12 March 2018

Loretto Kirribilli Redevelopment (SSD 7919) Response to Submissions (RtS)

Olivia Hyde
Director of Design Excellence

Concept Proposal Envelope Elevation

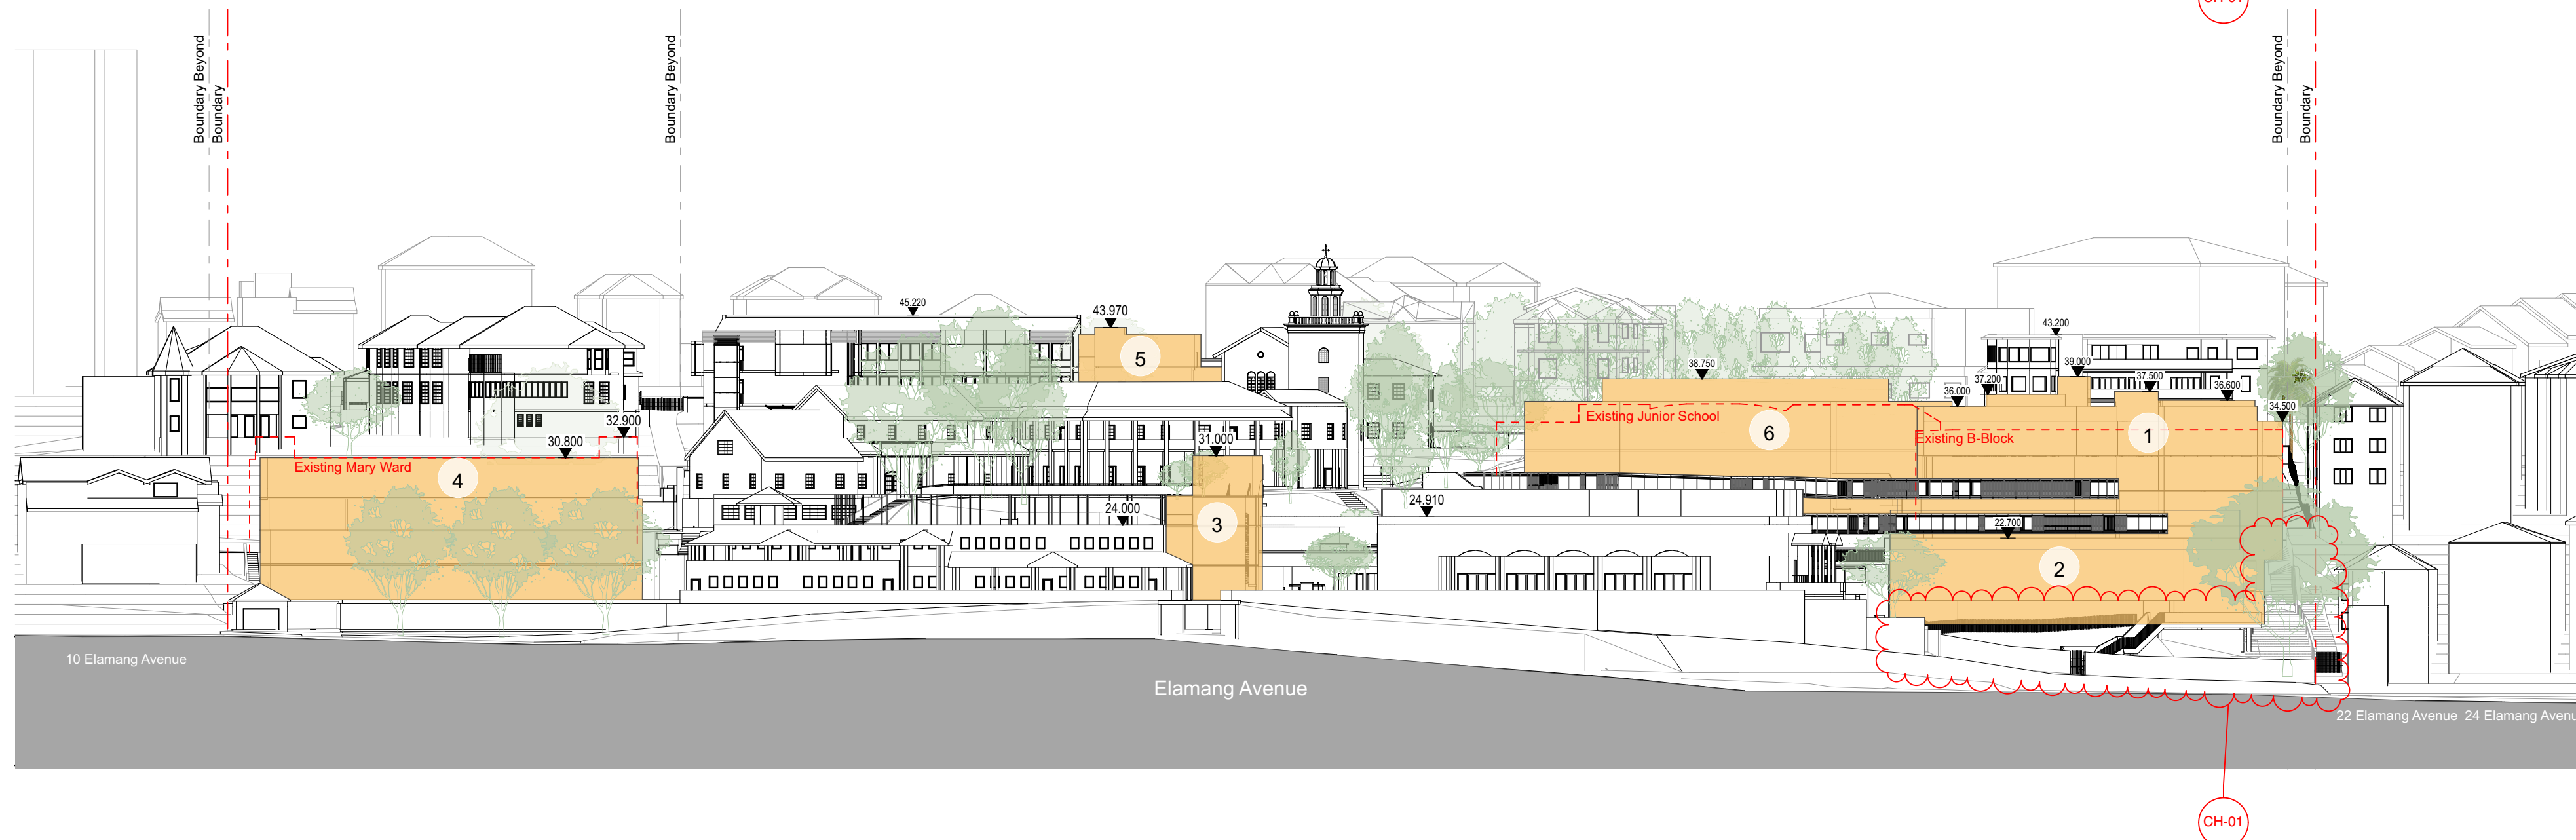
- Does the mechanical plant need to be so close to the boundary, or on the roof at all?
- Could the arrangement of rooms on Learning Hub Ground Floor and Level 1 be designed to enable the building to be brought further off the western boundary?
- Is it necessary that the learning hub lift stop at the roof terrace level, or could that level be served by the existing lift in The Marian Centre? We note that the lift does not seem to serve the roof terrace as there is a further flight of three steps between the lift landing and roof terrace.

- Could the western end of the Learning Hub's northern façade (the area to the north of the proposed plant enclosure) be lowered to improve neighbours' views?
- Could the roof terrace be reconsidered to become a planted roof, accessible by maintenance staff only? This may eliminate the need to add the additional two flights of stairs and additional lift level, reducing the bulk and scale of the building and restoring views
- The final point in our letter of 9th November 2017 as not been addressed adequately. Where the Western elevation of the Learning Hub is visible only to the western neighbours – who are disadvantaged by the use of dark bricks with little light reflectivity- can that elevation be in a light material to maximise reflected daylight penetration?
